Designing Out Crime Officer

To: Emma Thompson Kirklees Council Planning Services Civic Centre 1, High Street, Huddersfield, HD1 2NF	Ref: 2020/91919 Date: 13 th July 2020
--	---

Site Location: The Co Operative Food, 19 Northgate, Almondbury HD5 8RX

Application Type: Demolition of supermarket and erection of block of 6 flats

drg no.
3570-03

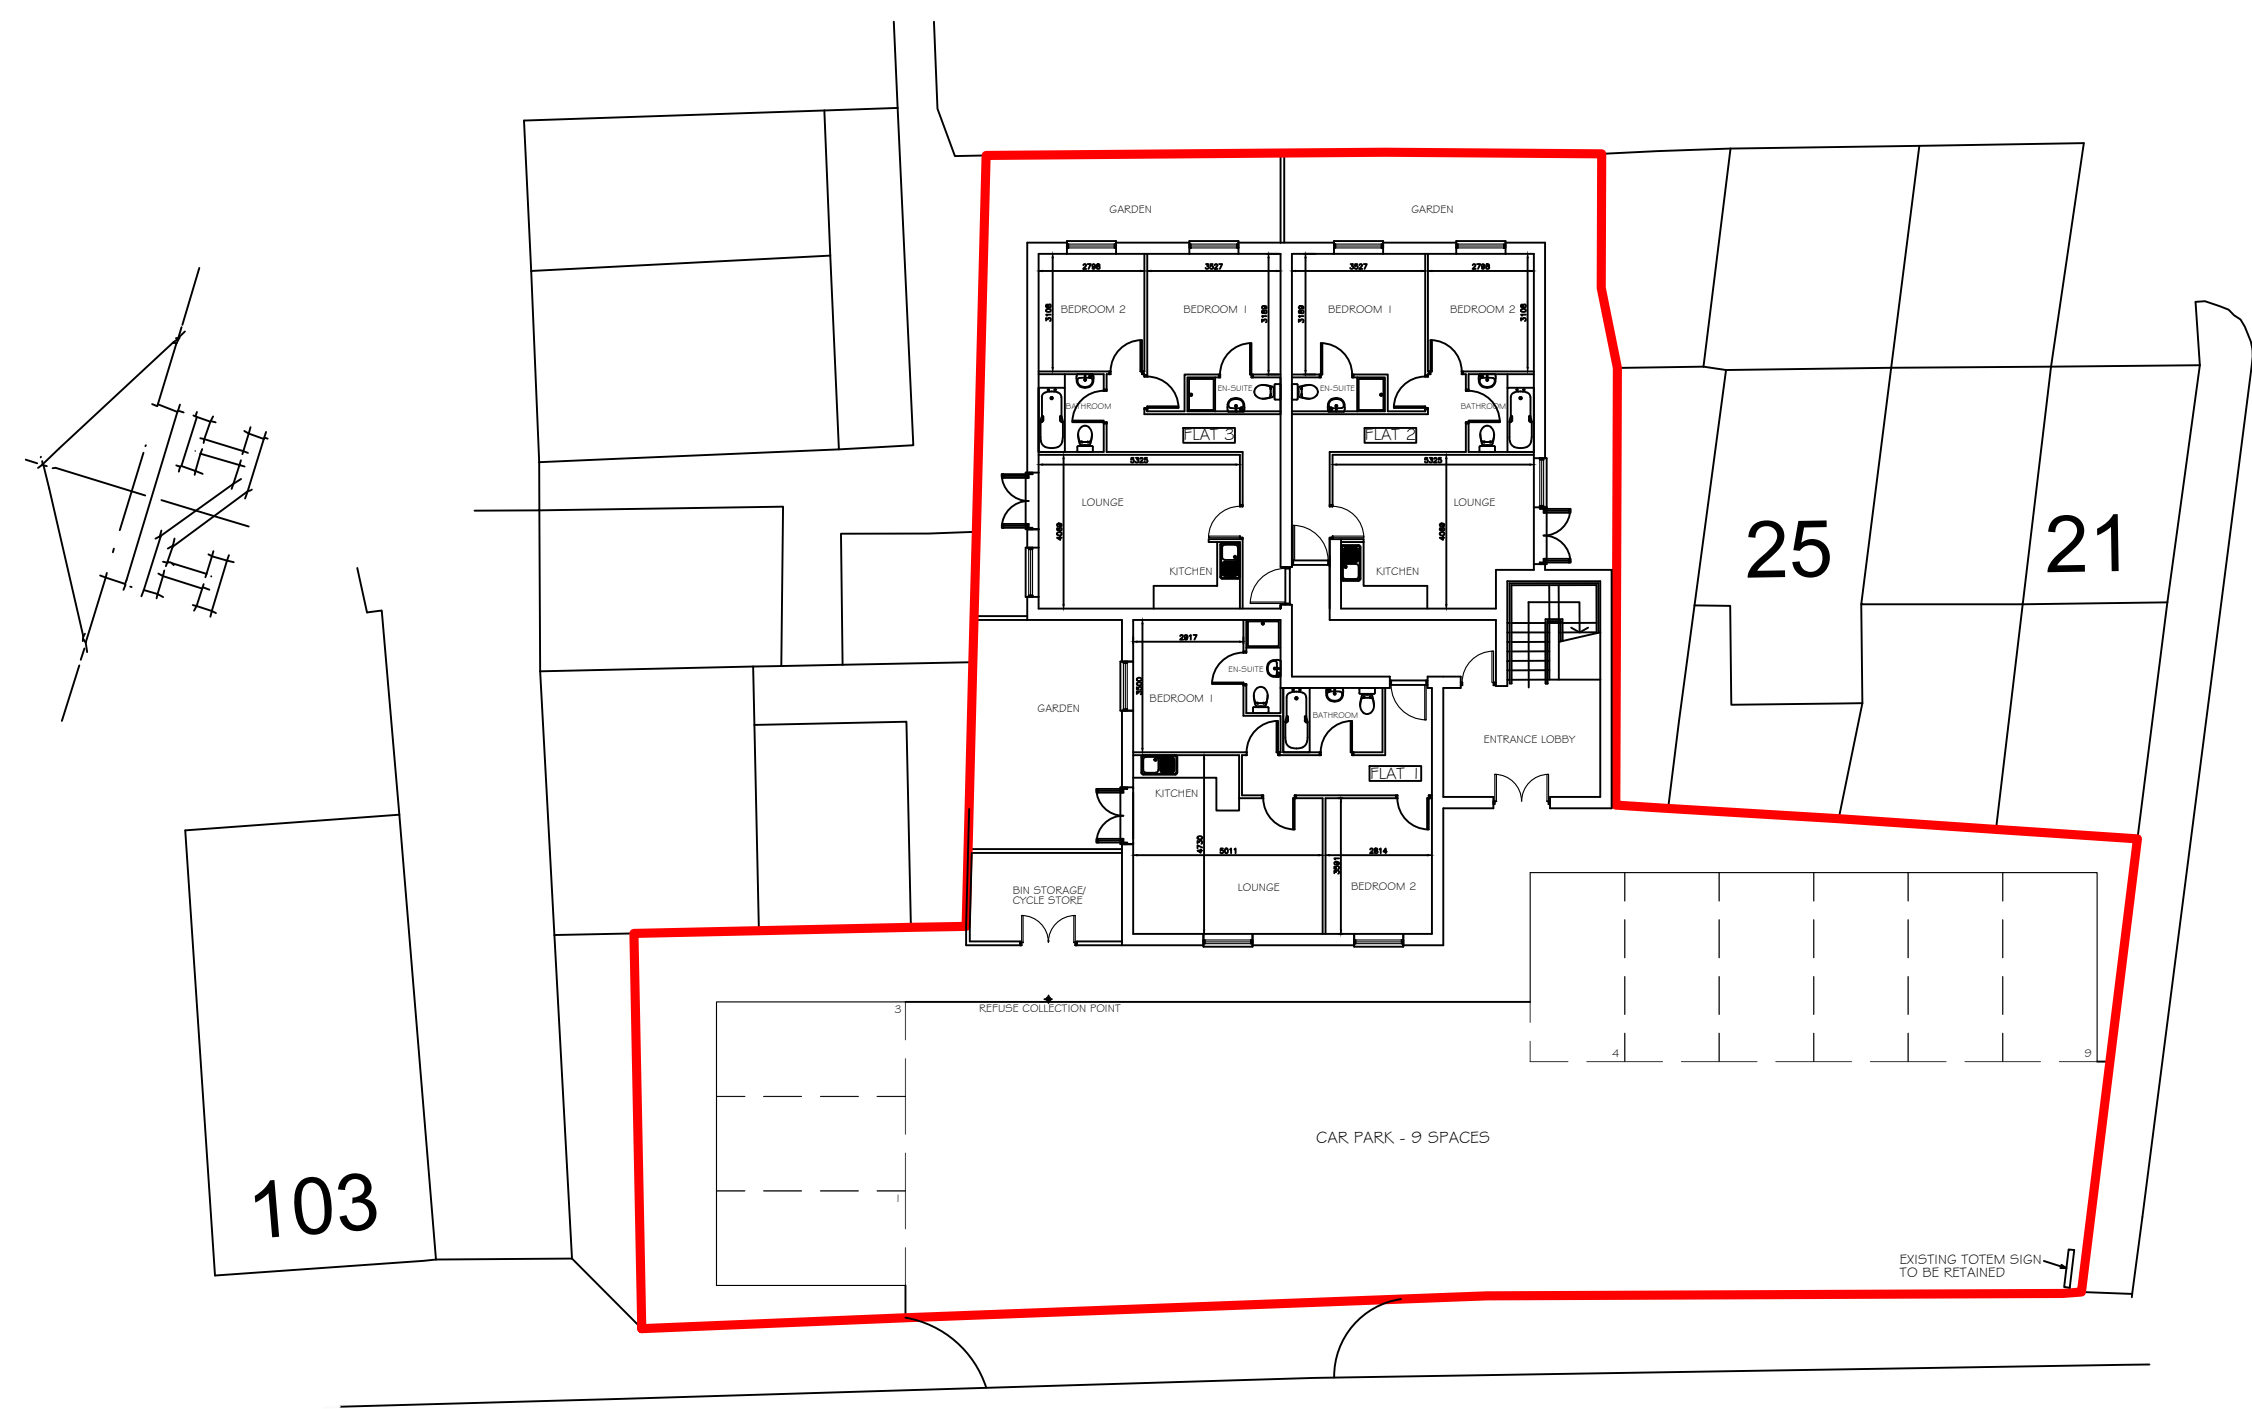
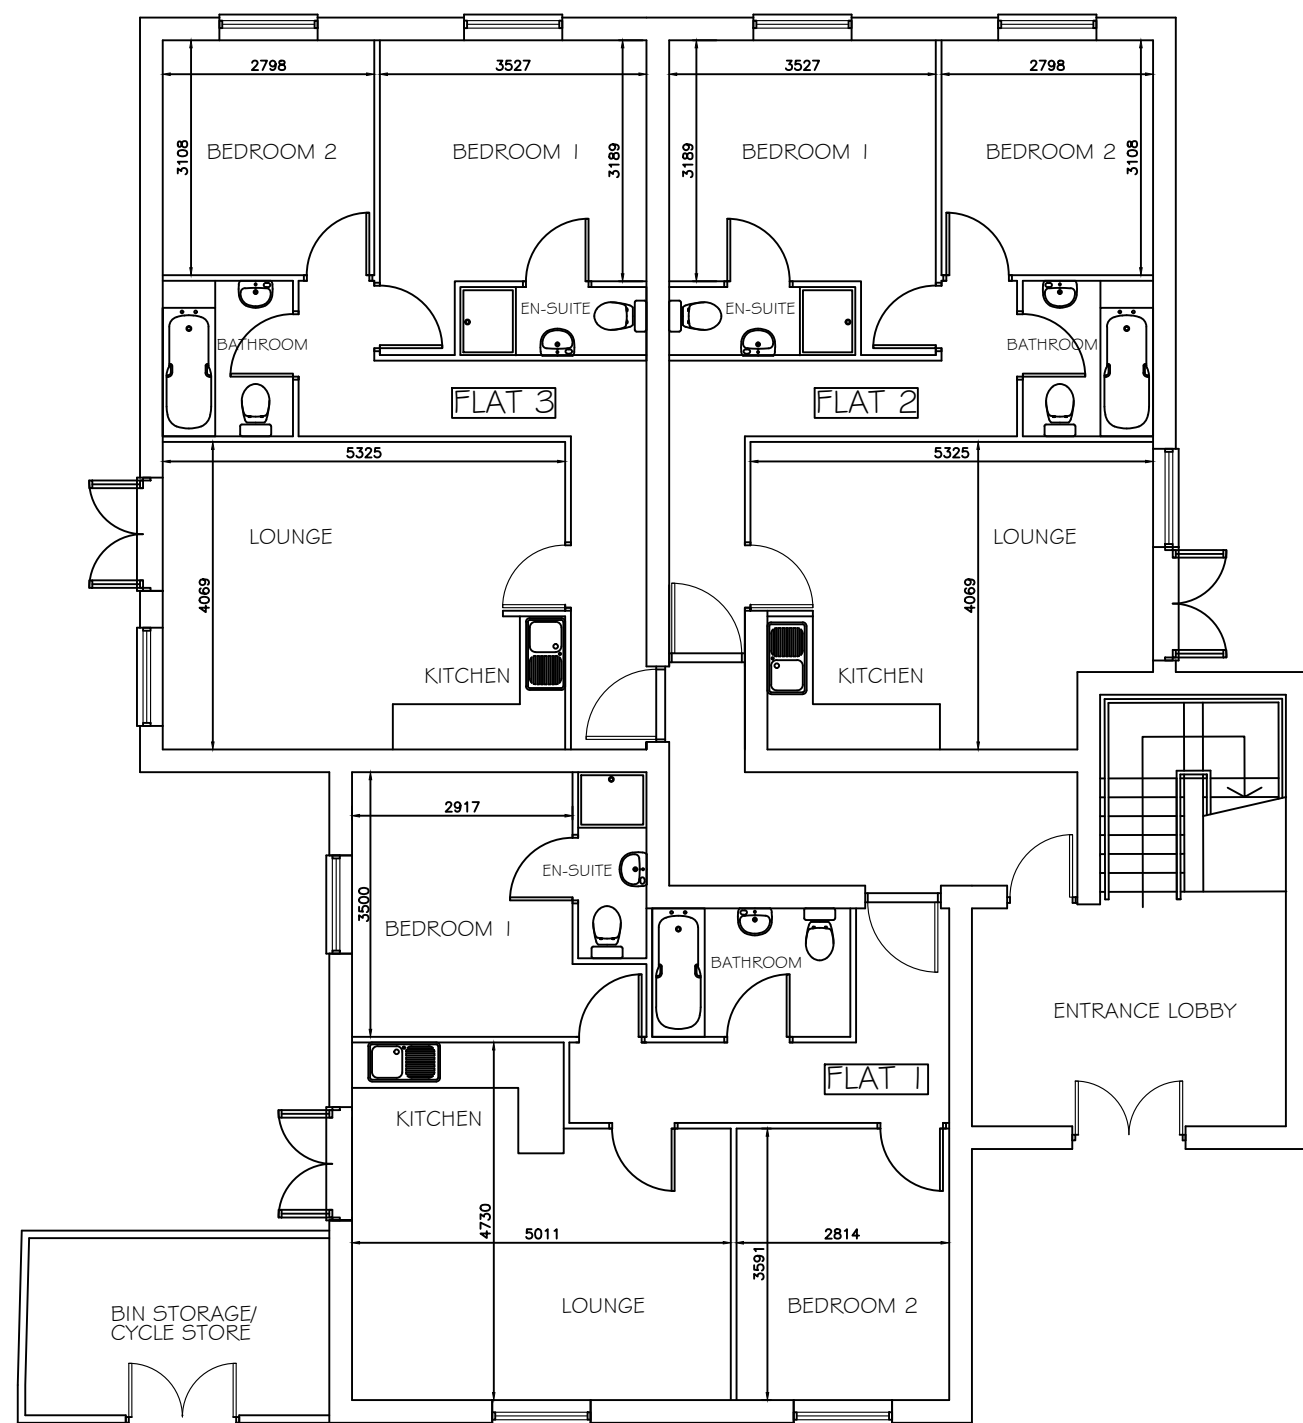
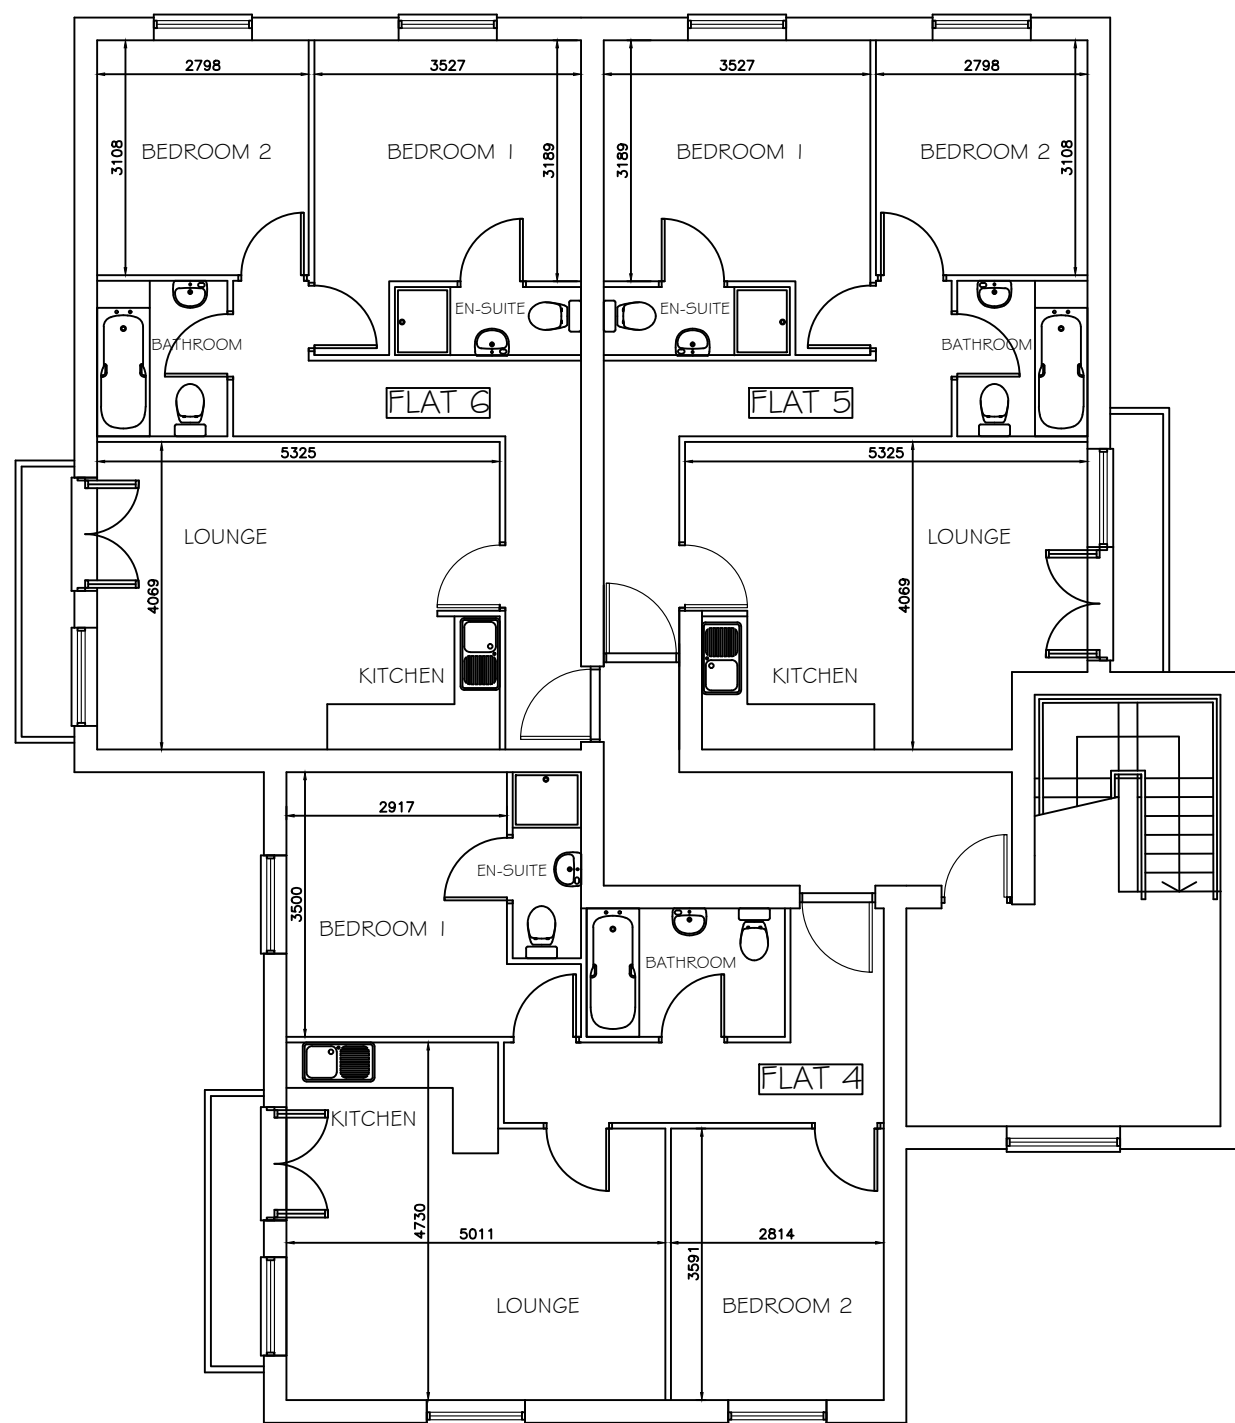
Referring to site plan drawing number 3570-03 dated June 2020.

It is recommended that this property has access control to the main entrance and communal areas leading to individual dwellings. This can be key / keypad / fob or swipe entrance systems to prevent unauthorised entry.

Climbing access to the first floor balconies must be restricted. Fall pipes, fencing and external storage areas must not be within reach of the balconies to prevent intrusion.

There is little natural surveillance of the car park from the dwellings. It is advised that the parking space in front has a defensible border to prevent easy access by offenders. Any fencing should be open spaced boarding with at least 25mm gaps between the boards, fitted flush to any boundary wall and to a minimum height of 1.8m. I would be preferable to have active frontages to the dwellings overlooking the car park, especially towards spaces 4 to 9.

It is recommended that the parking spaces have adequate lighting covering the vehicles.
